PROJECT NO. PR-2022-007875
Application No. SI-2022-02109-SITE PLAN

SUBMITTAL DESCRIPTION: Revised Site Plan, Landscape Plan Infrastructure List and Deviation Justification

Memorandum

Project: Kimmick & Rosa Parks

PLAN # <b>300</b>
DESCRIPTION: <b>DUPLEX</b>
<b>EXTERIOR ELEVATIONS</b>
CLIENT: ABRAZO HOMES
CONTRACTOR: TQM, LLC NM LICENSE # 366615
SCALE: AS NOTED
DATE: 9/6/2022
SHEET # 9

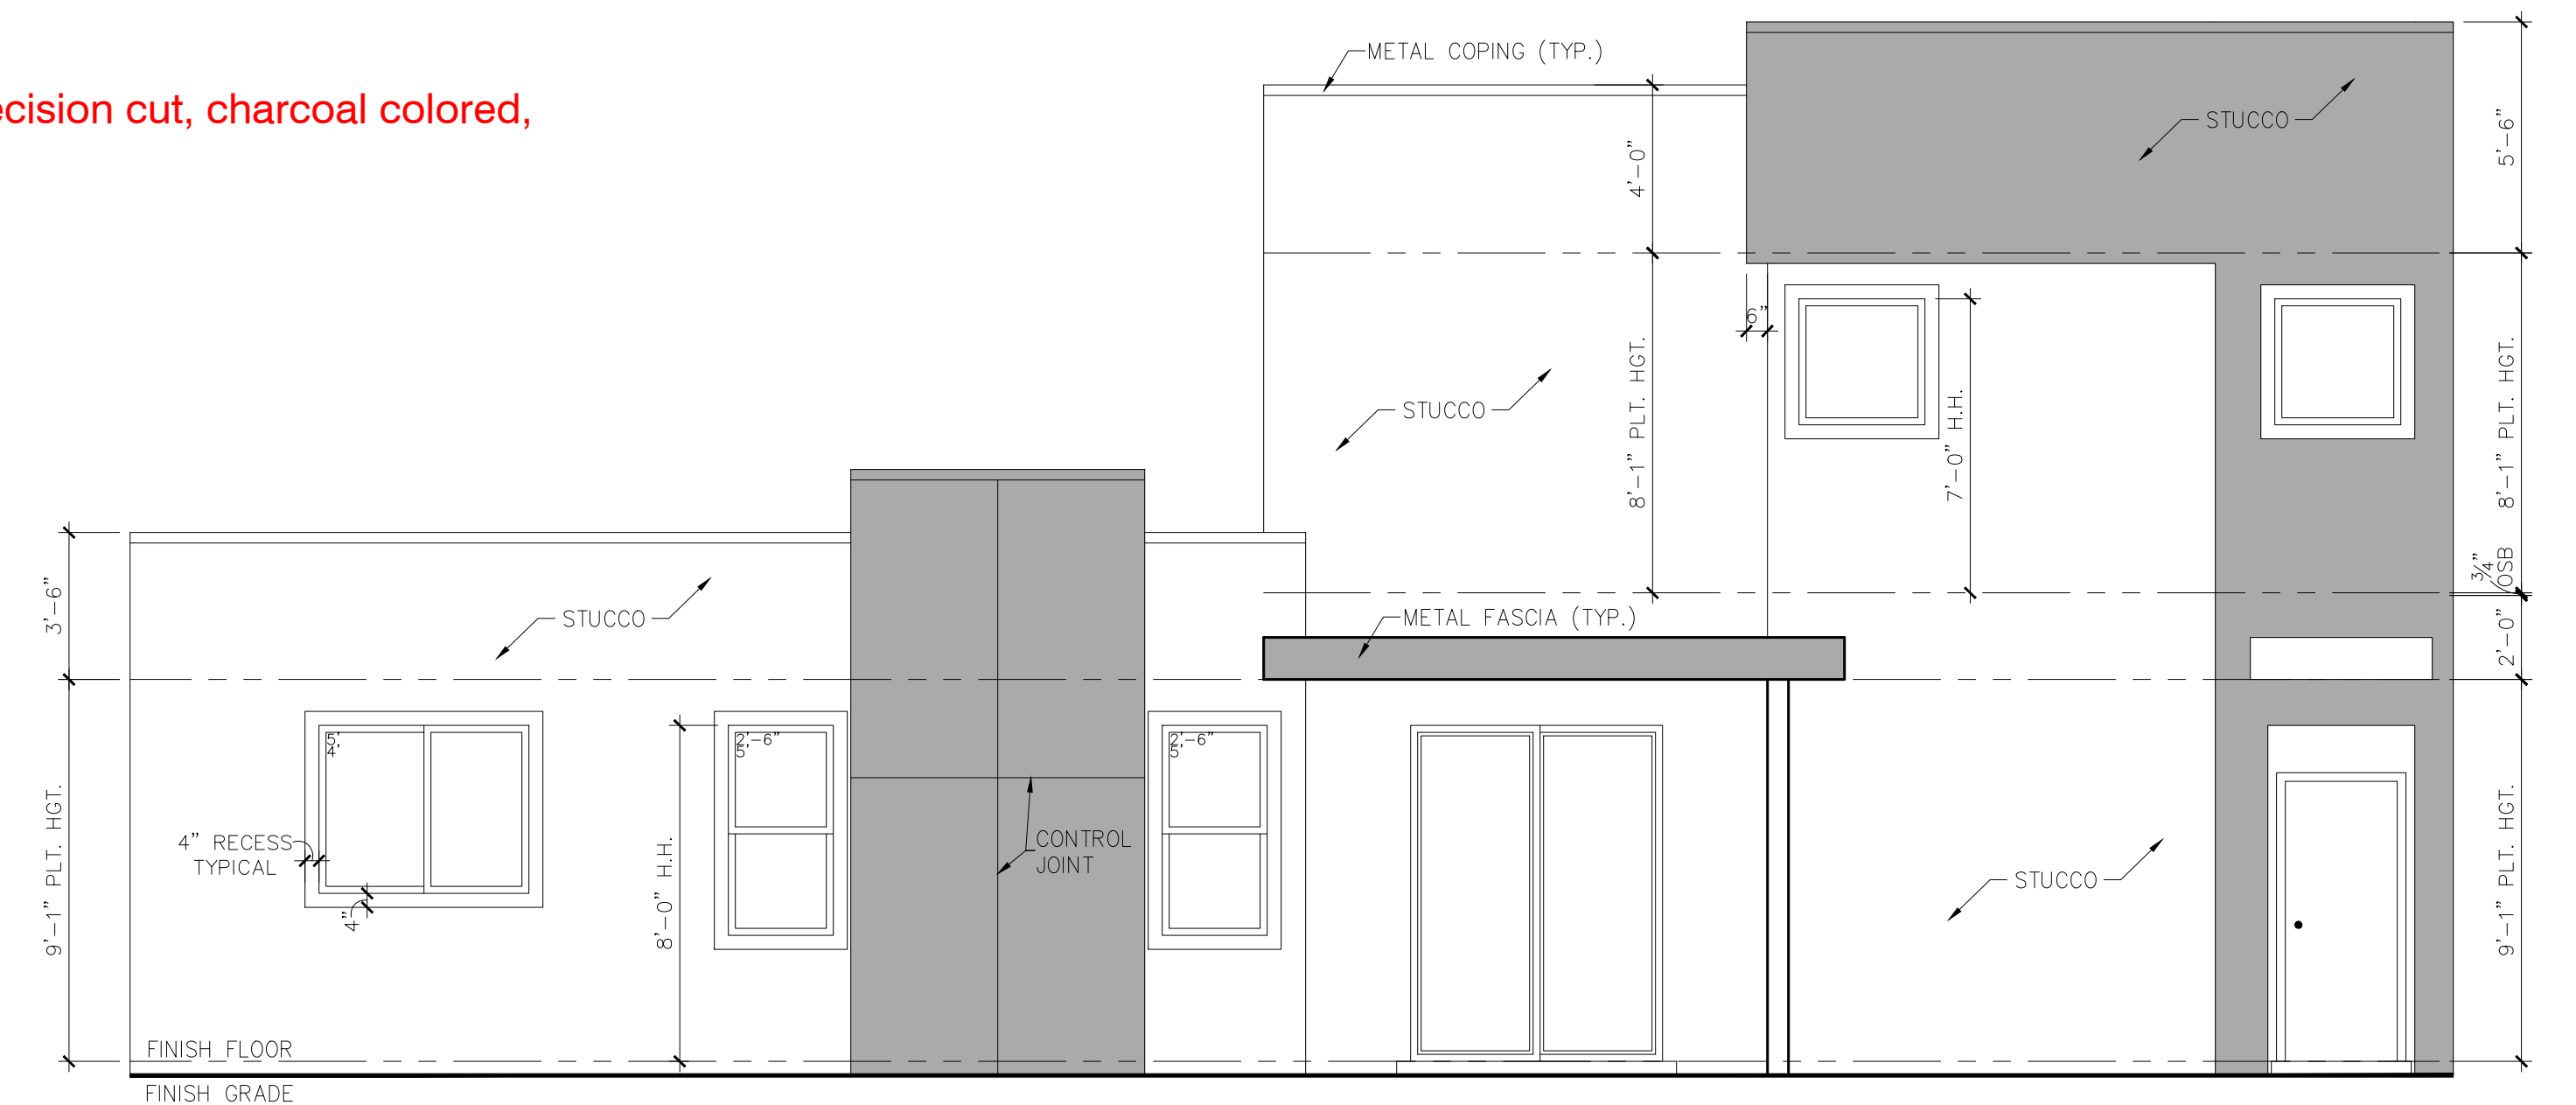
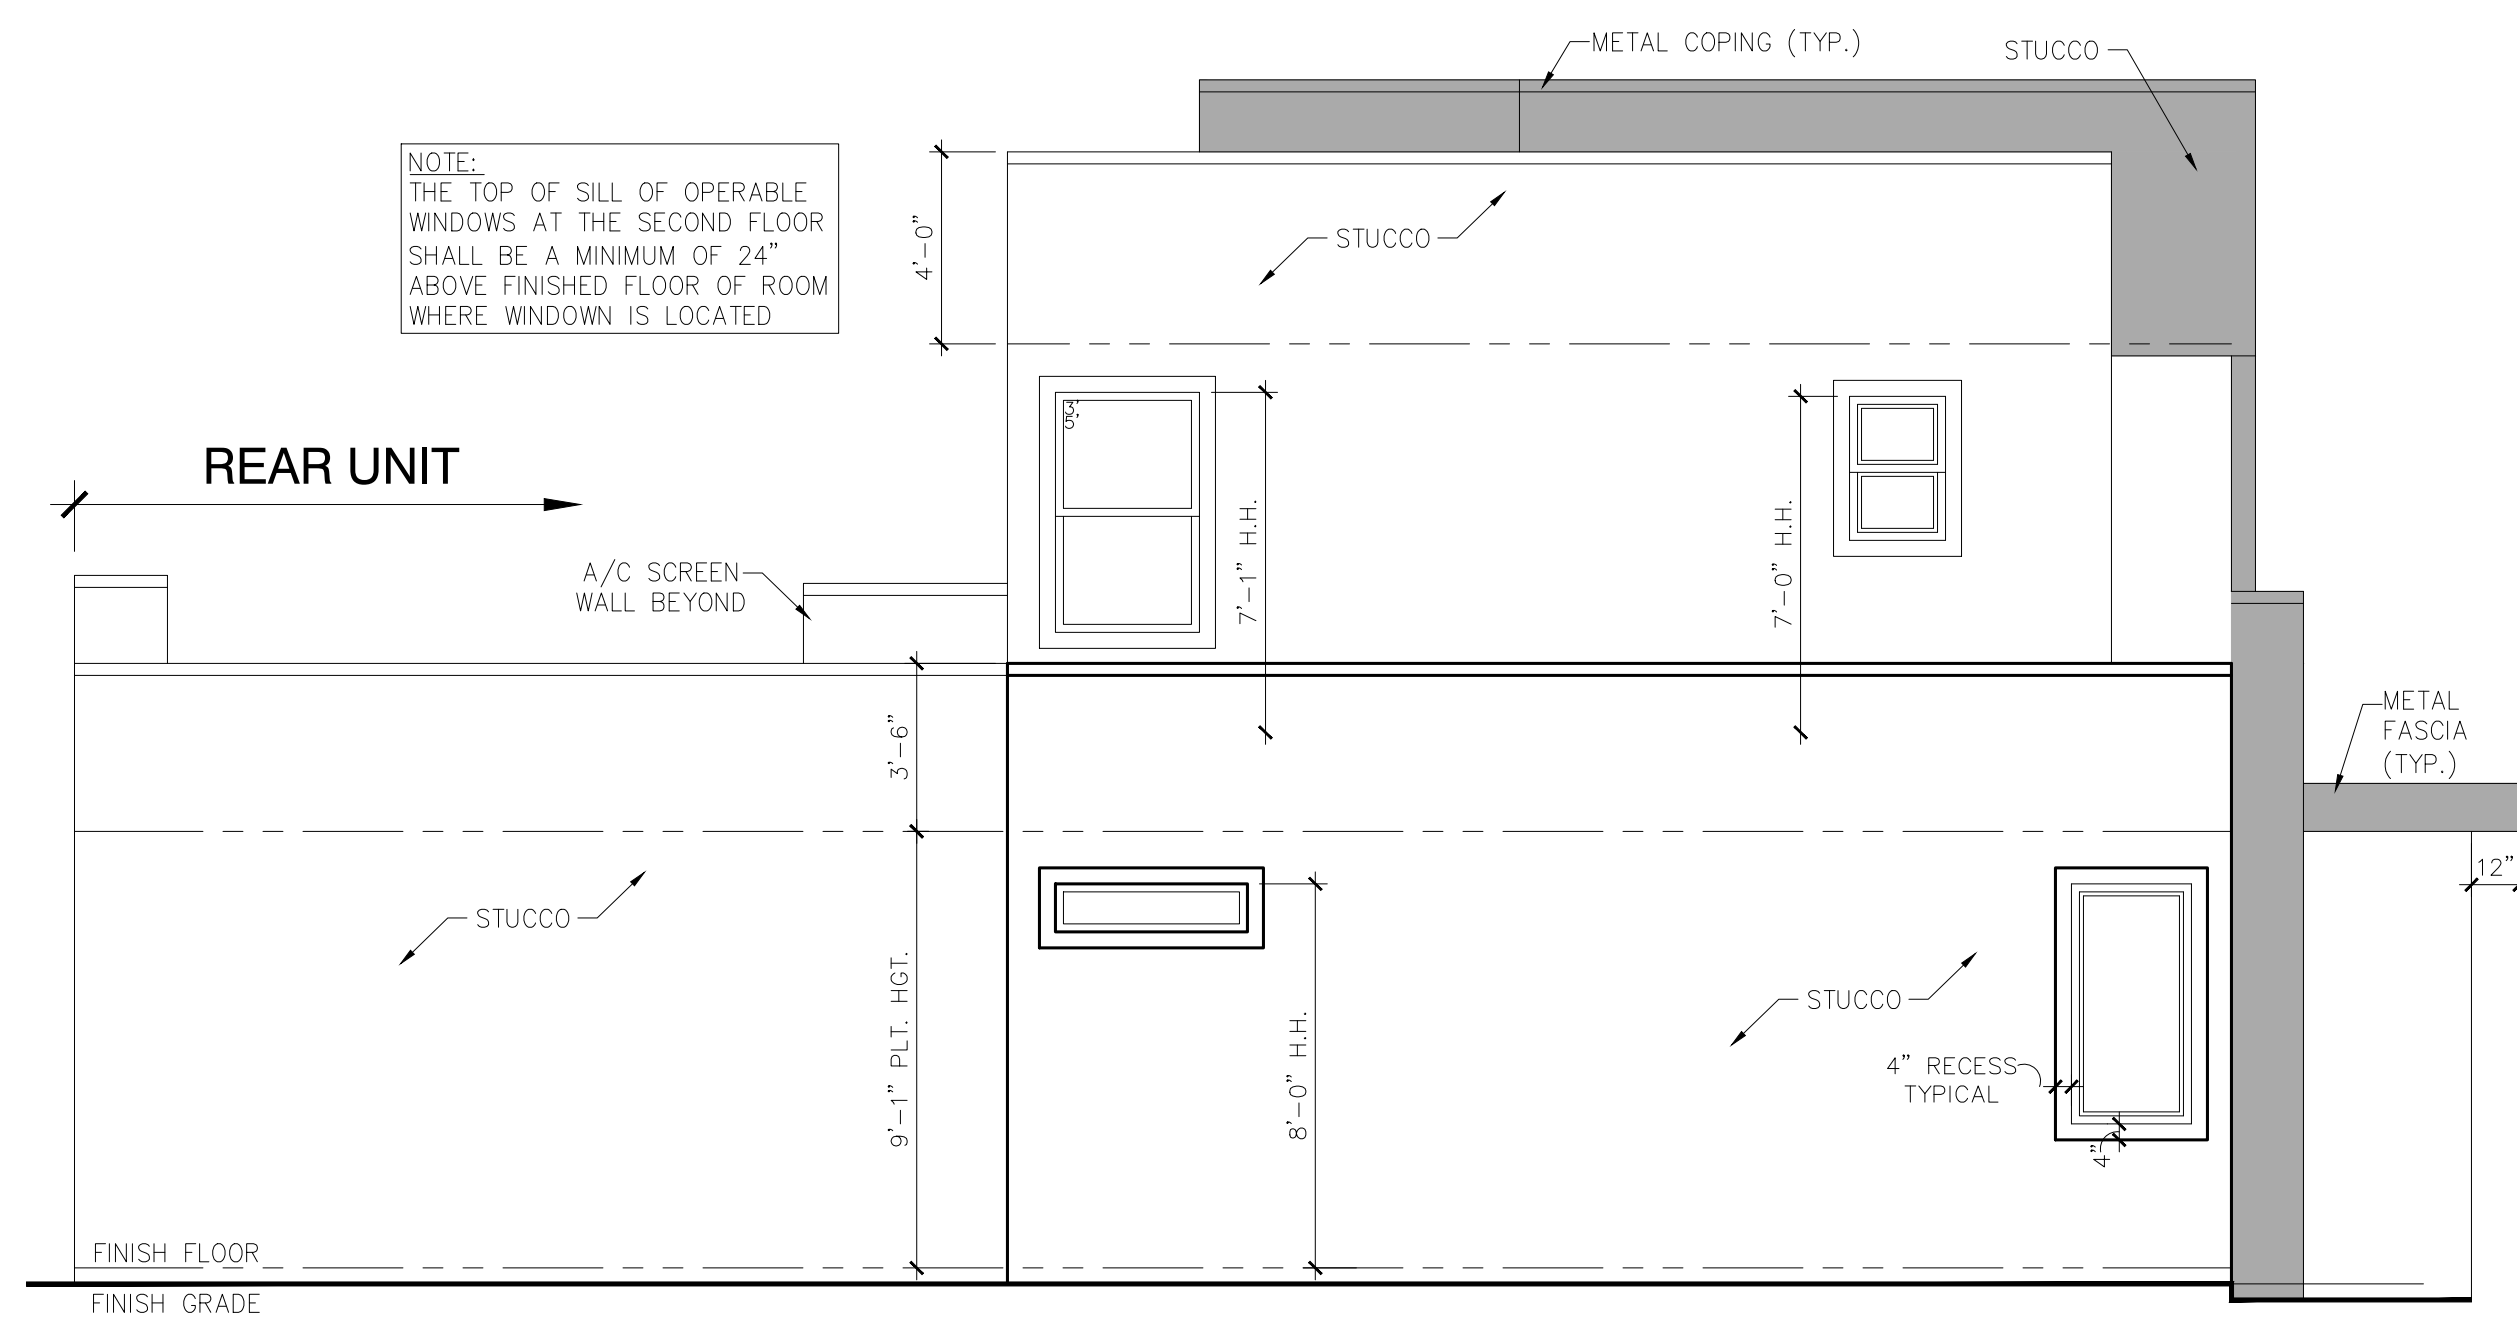
- 1. Limit the colors of exterior surfaces of structures, including but not limited to mechanical devices, roof vents, and screening materials, to those with light reflective value (LRV) rating between 20 percent and 50 percent.*
- 2. Colors shall blend with the surrounding natural environment and generally include yellow ochres, browns, dull reds, and grey greens.*
- 3. Trim materials on façades constituting less than 20 percent of the façade's opaque surface may be any color.*

- 1. Design consideration has been made to ensure compliance of 5-2(J)1(d). All buildings will have exterior stucco color of Canvas with River Rock colored stucco*

and trim accents. Courtyard walls are contemplated to also be stucco and colored to match the building exterior. Please see colored renderings which are included with this site plan submission. The LRV for Canvas is 44.0 while the LRV for River Rock is 31.1.

2. Design consideration was made to ensure color palates which are in harmony with the surrounding high desert landscape. Please see colored renderings which are provided as part of this site plan submission.
